19 September 2022

**Re: Review of Flood Related Development Controls for Building Floors**  
**104-116 Regent Street, Redfern, Response to Council's Submission of 11 July 2022**

1 Level 1 (Ground)  
Floor Plan  
1 : 200

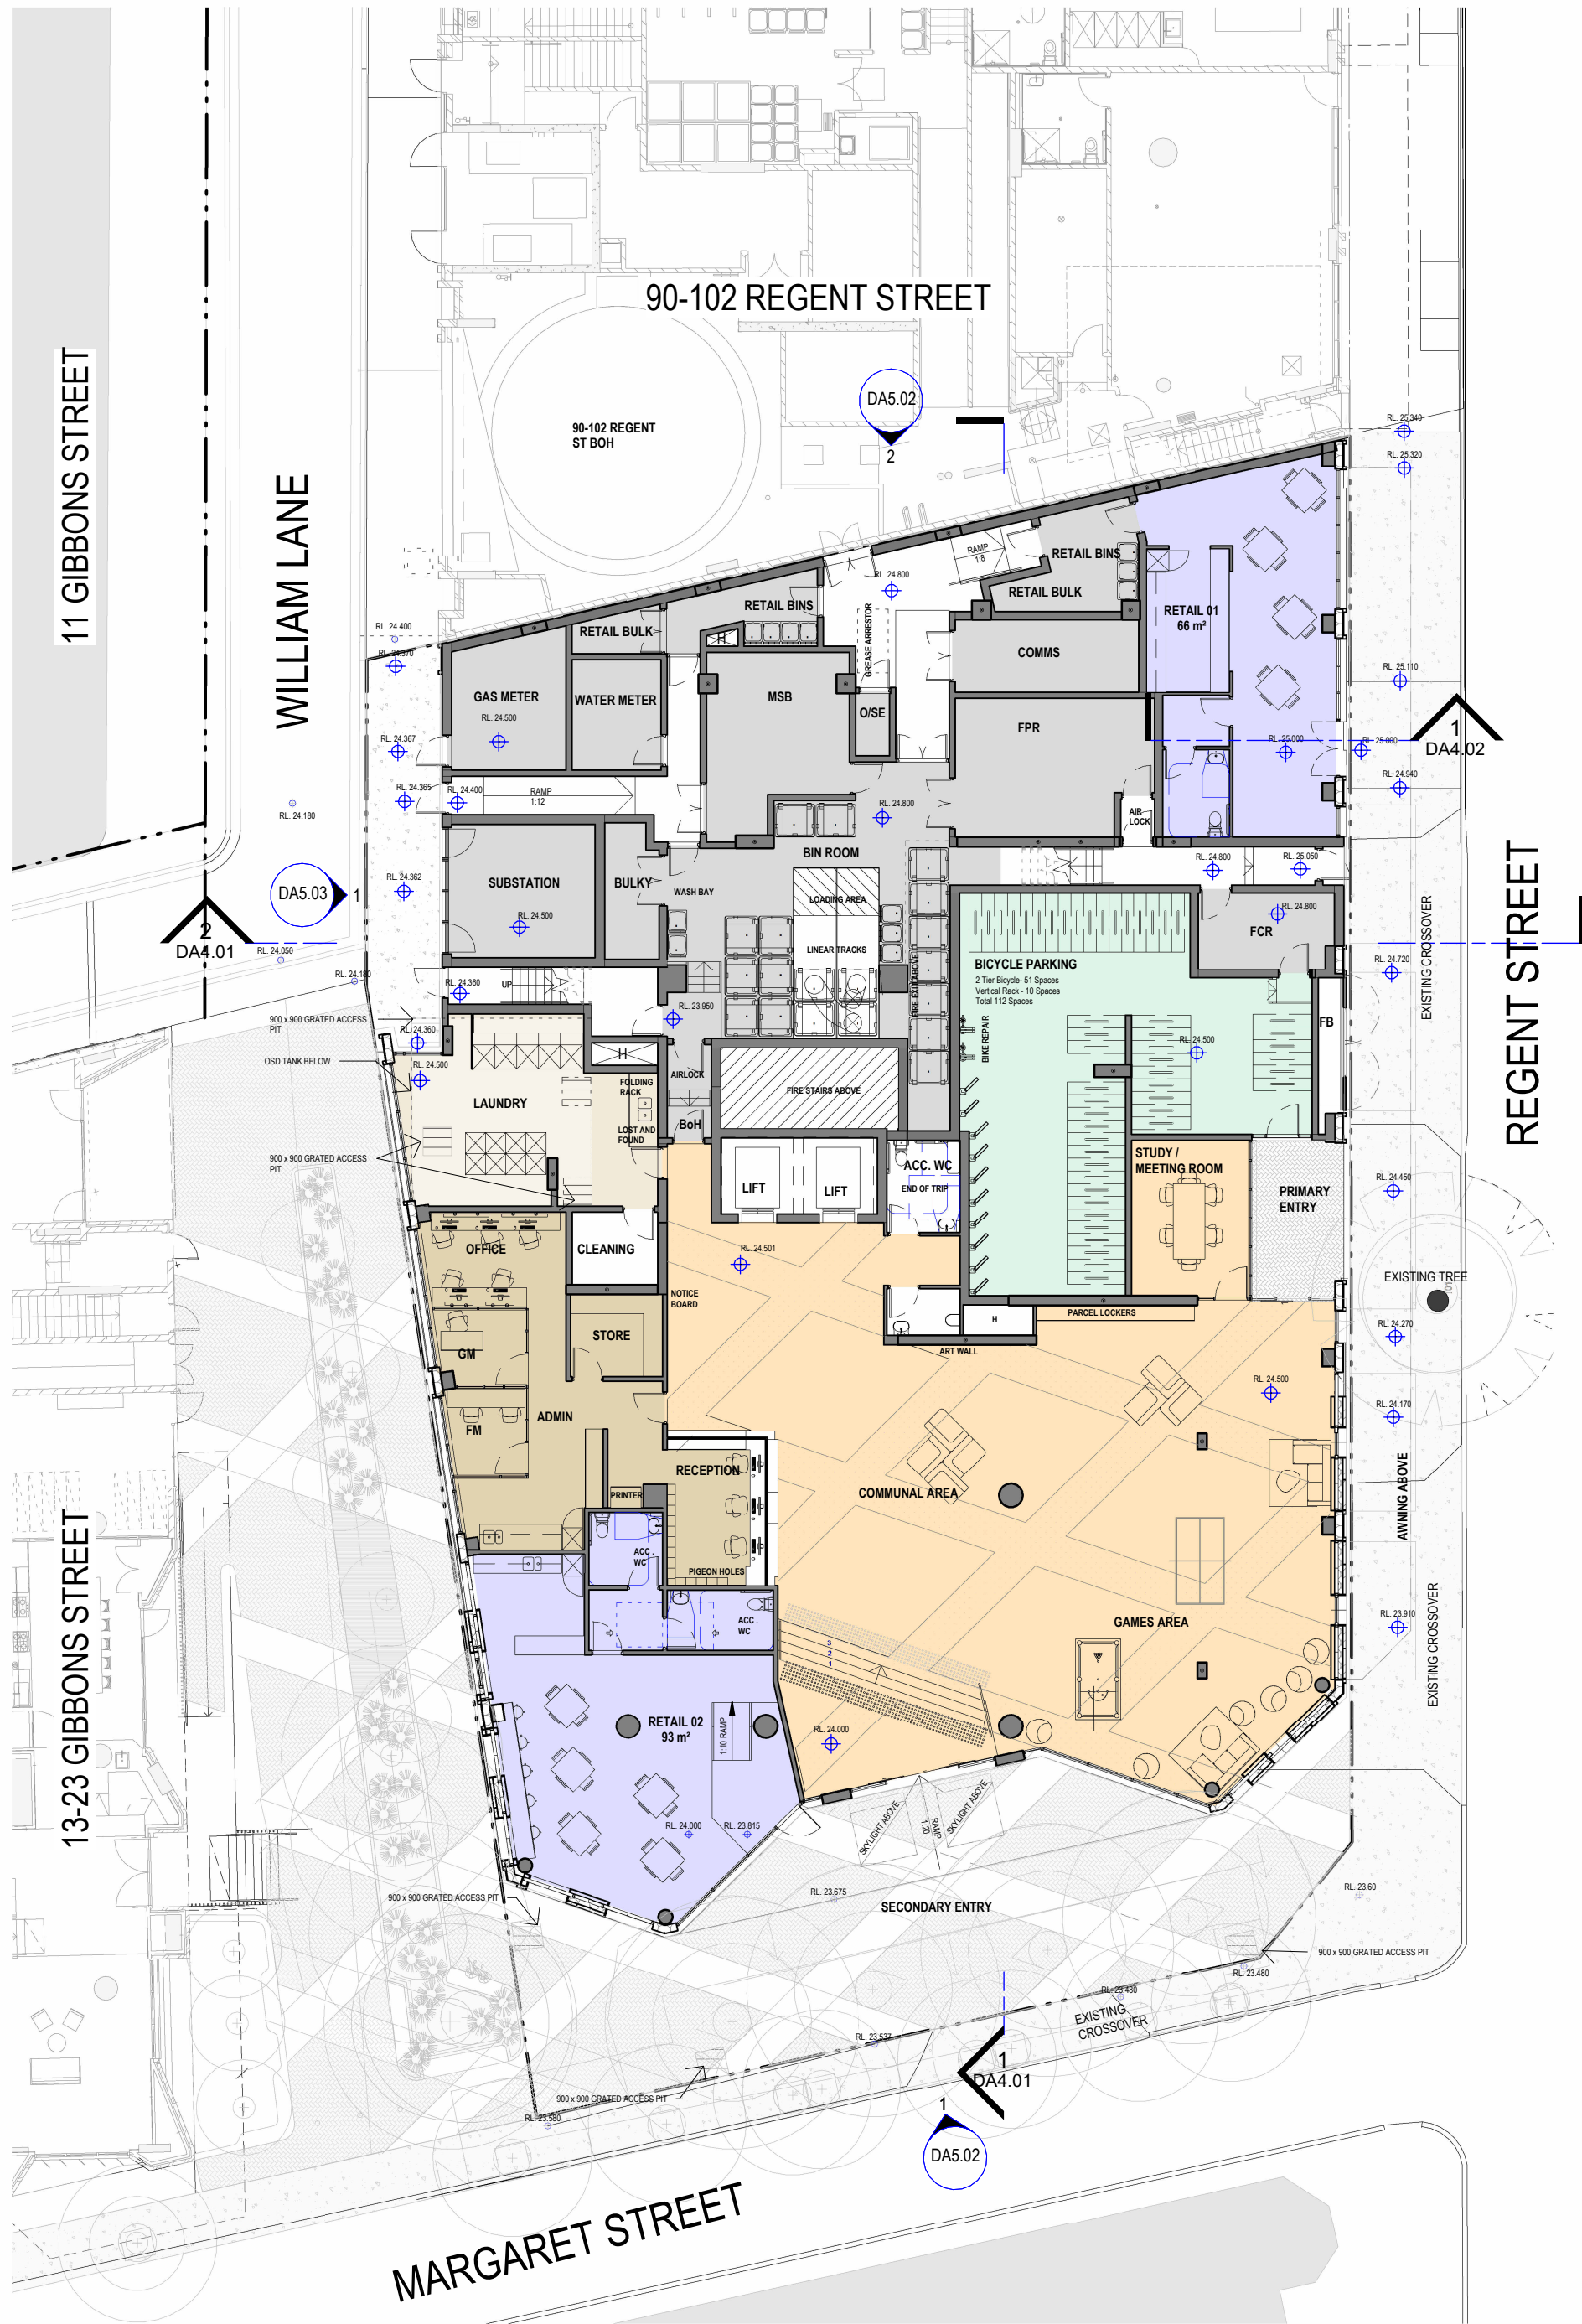
A new comment is raised in relation to flooding on the site. The previously submitted Flood Statement, prepared by WMA Water, incorrectly states entry door nos. 10 and 11 as having a freeboard of 100mm for the internal 1% AEP. However, it has a 0.0 freeboard. Clarification is required on the necessary freeboard for the proposed development.

This letter responds to Council's comments in their letter of 11 July 2022 and provides an updated table (refer below) listing the description of the internal space at each door, the finished floor level (FFL) and the 1% AEP and PMF flood levels. Also listed are the height of the FFL above the 1% AEP and PMF flood levels. It should be noted that whilst the proposed finished floor levels on the plans are quoted to 2 decimal places the peak flood levels at each door cannot be accurately quoted to 2 decimal places.

We have reviewed the requirements of Council's Interim Floodplain Management Policy and the proposed finished floor and design flood levels. For "Business" use the minimum is the 1% AEP flood level and the above table indicates that this is achieved.

However, all critical facilities (electricity supply) or any use that is critical to the operation or use of the space (computers, electricity outlets etc.) must be located above the PMF flood level. There is little difference between the 1% AEP and PMF flood levels as the floodplain (i.e., the streets) are relatively wide and thus an increase in flow produces only a small increase in peak flood level.
